Our Ref: SDNP/21/00774/ADJAUT
Contact Officer: Karen Wooden

Neighbouring Authority Consultation

Proposal: Adjoining Authority Consultation - Proposed 2 storey front extension and loft conversion.

Address: 14 Queens Lane , Arundel , BN18 9JN, ,

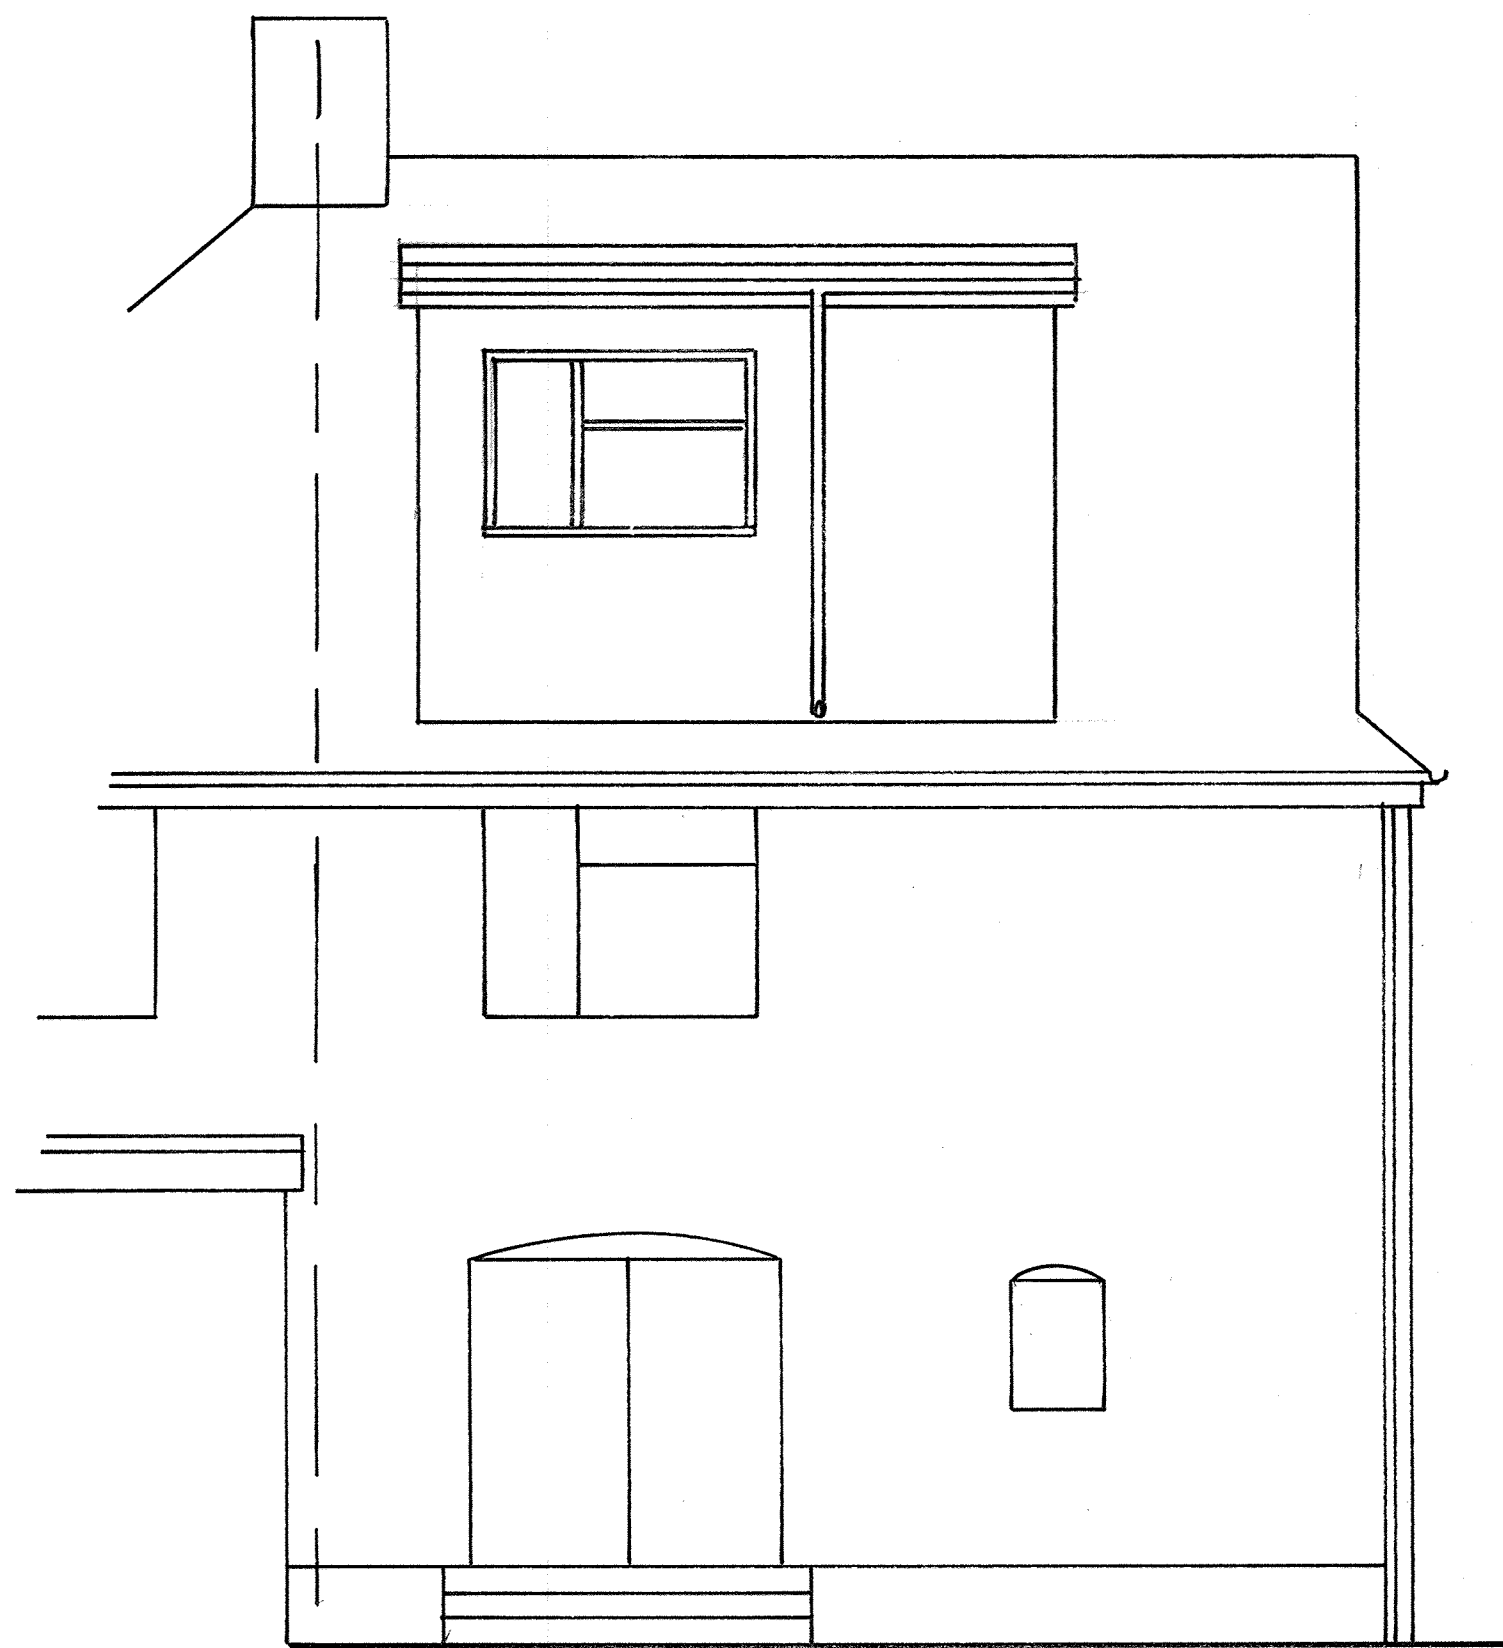
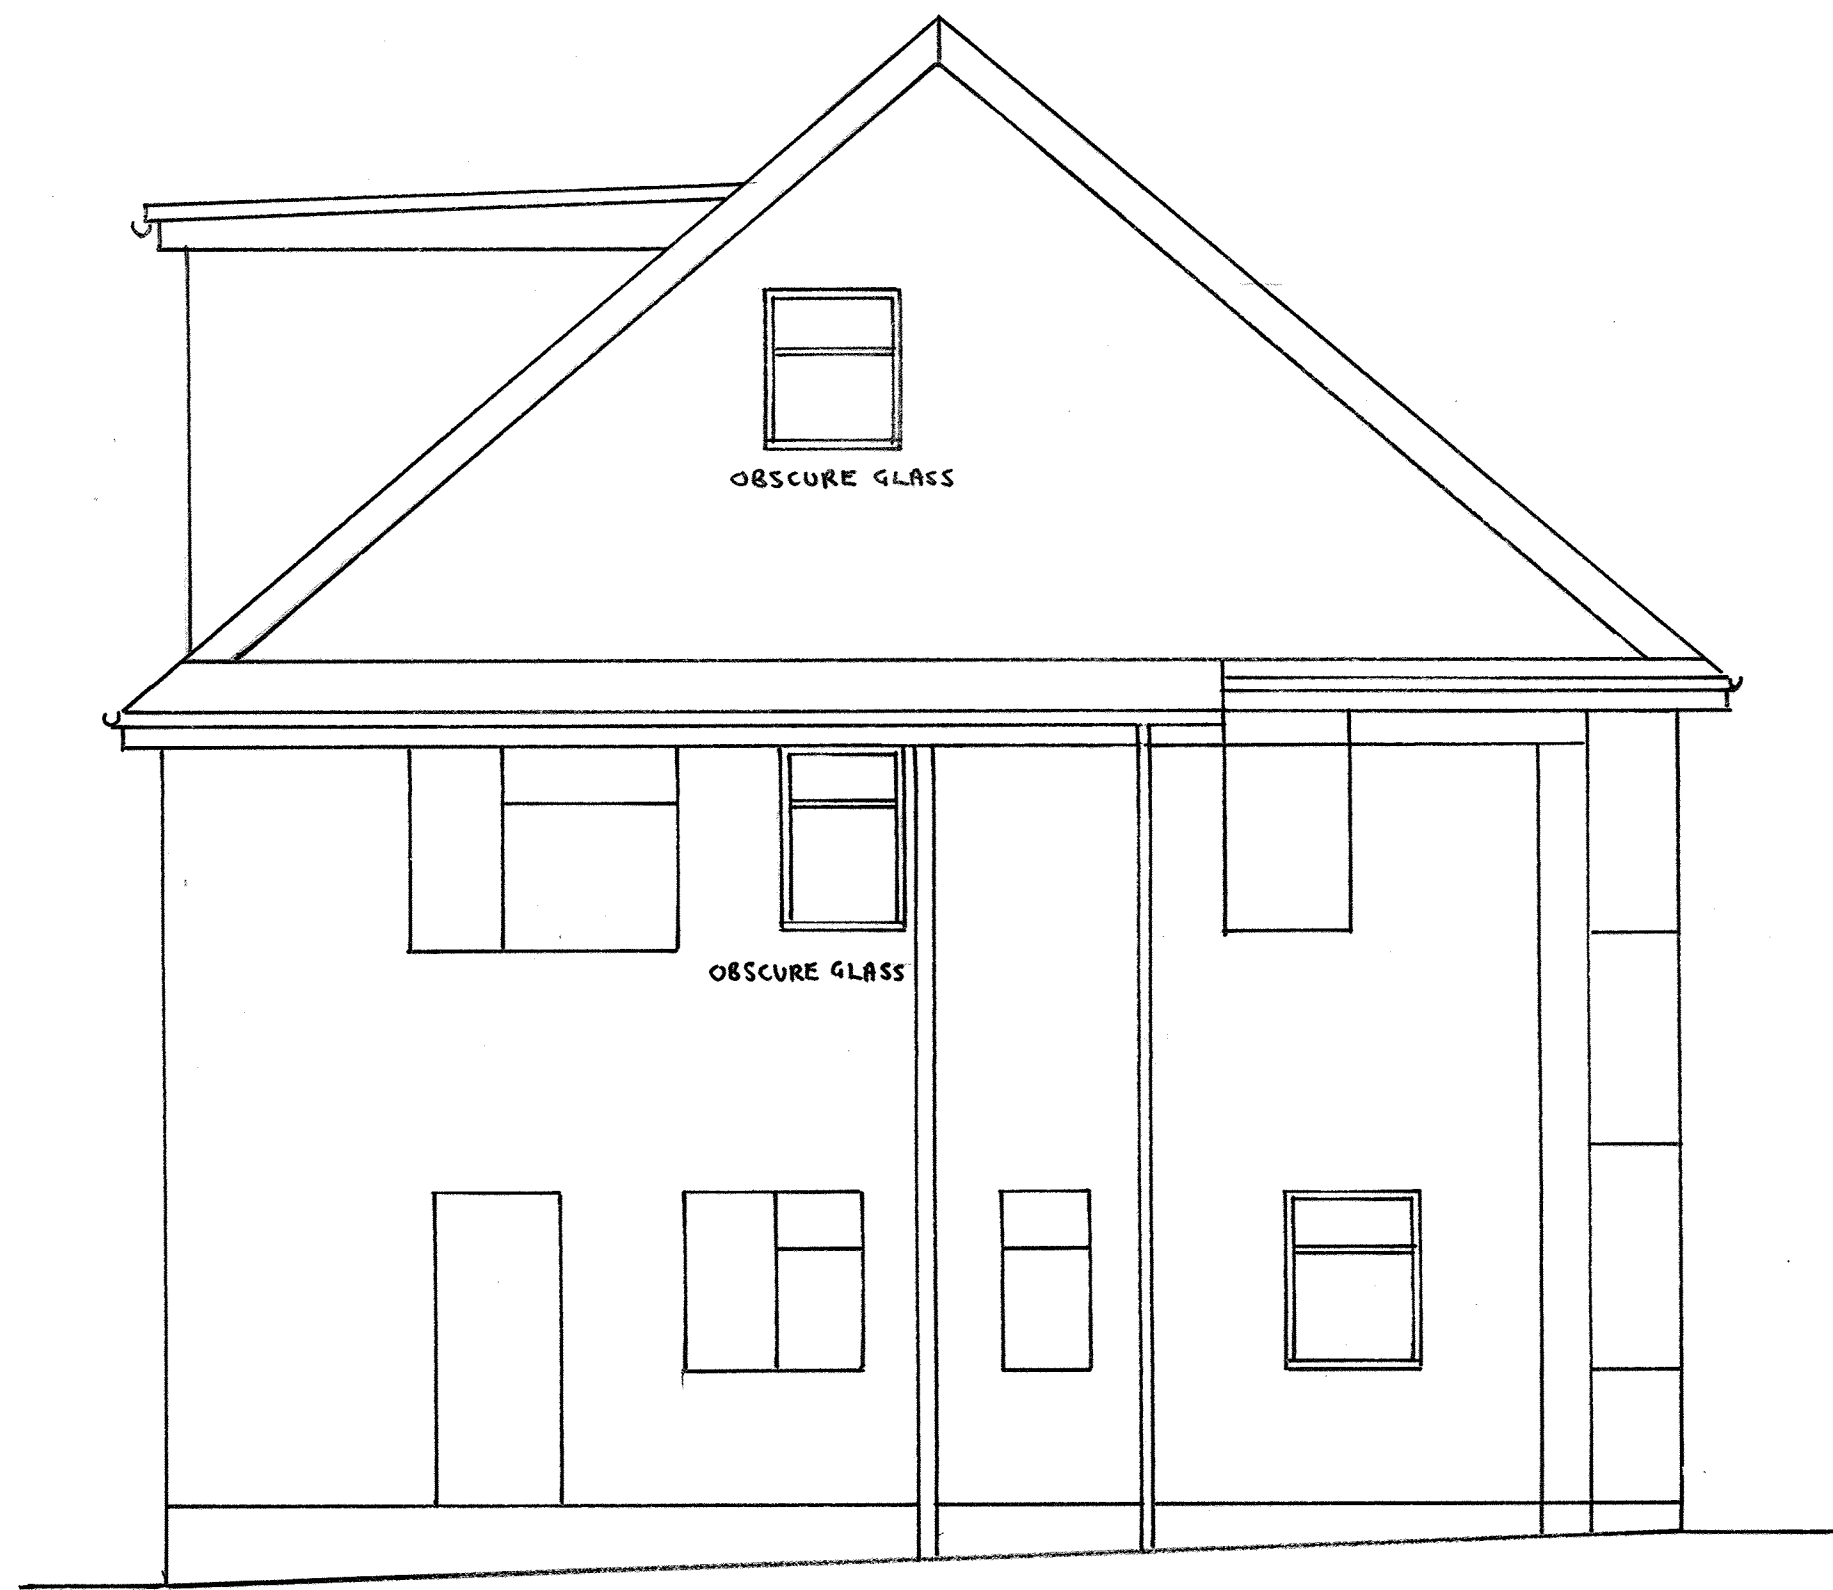
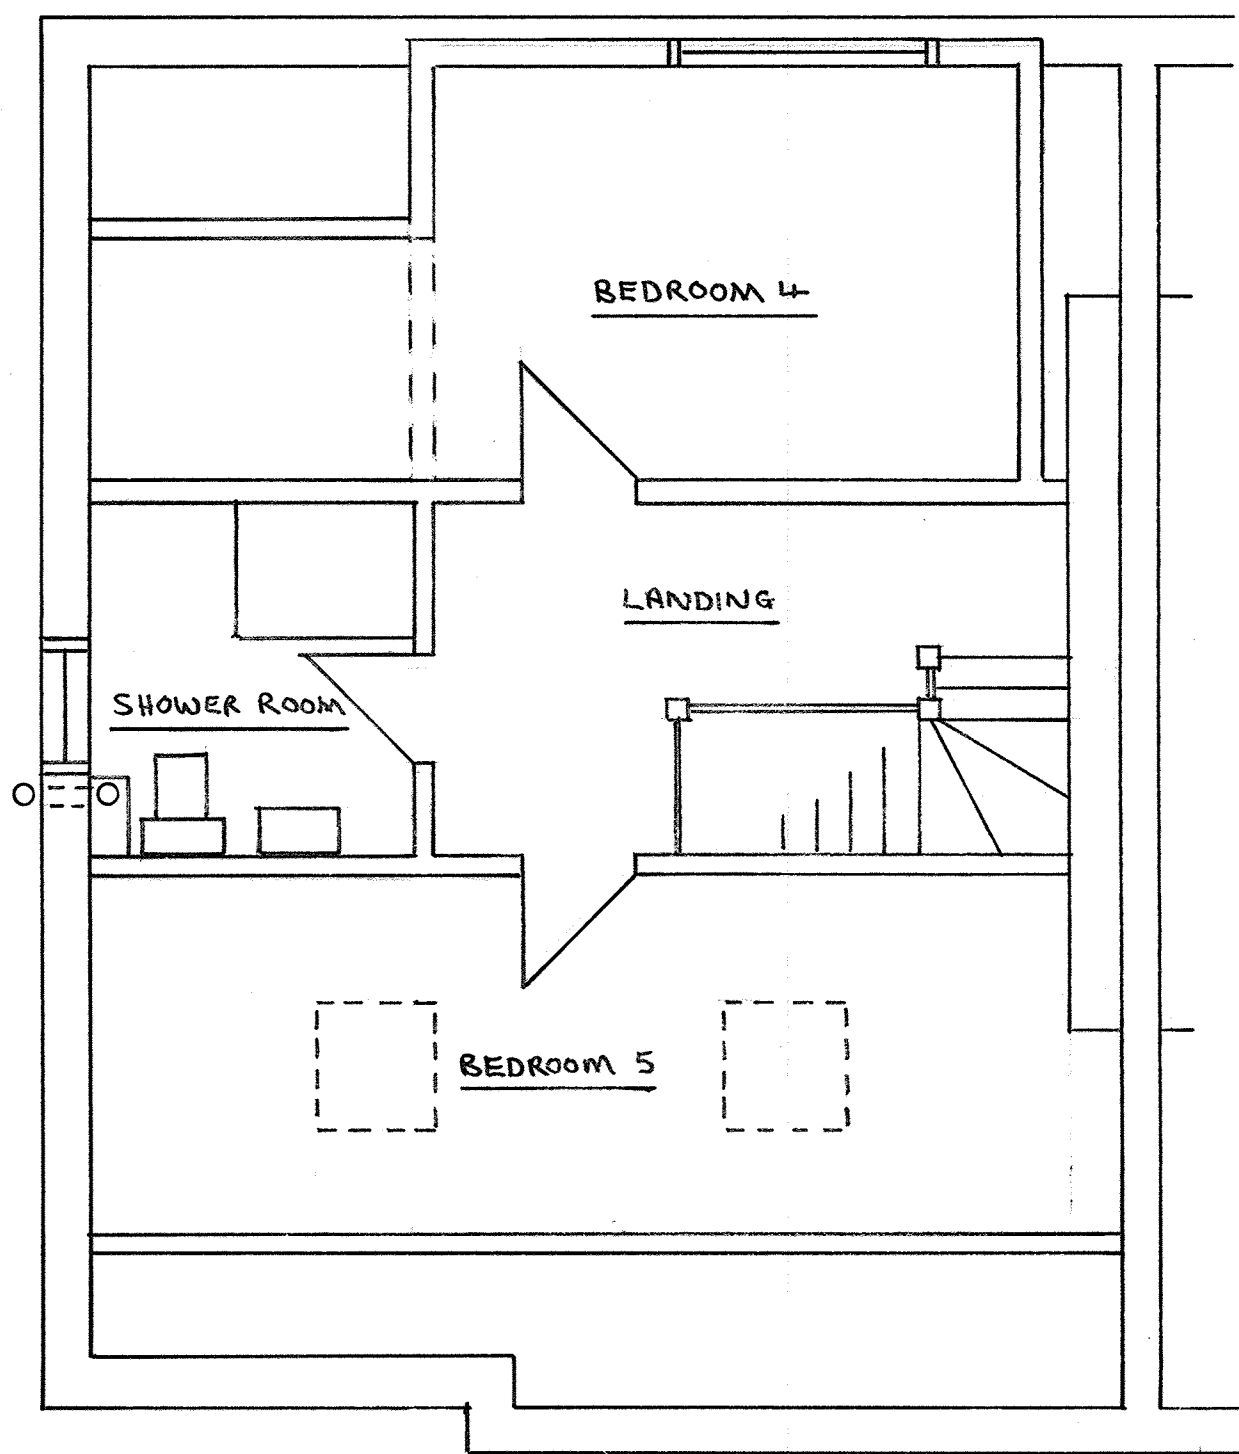
The application form confirms the proposed materials to be brick and tiles. These should be of a similar appearance to those used on the host dwelling. The front extension and loft conversion

are considered to be of an appropriate scale and design, and are not considered to cause significant harm to the visual amenity of the National Park.
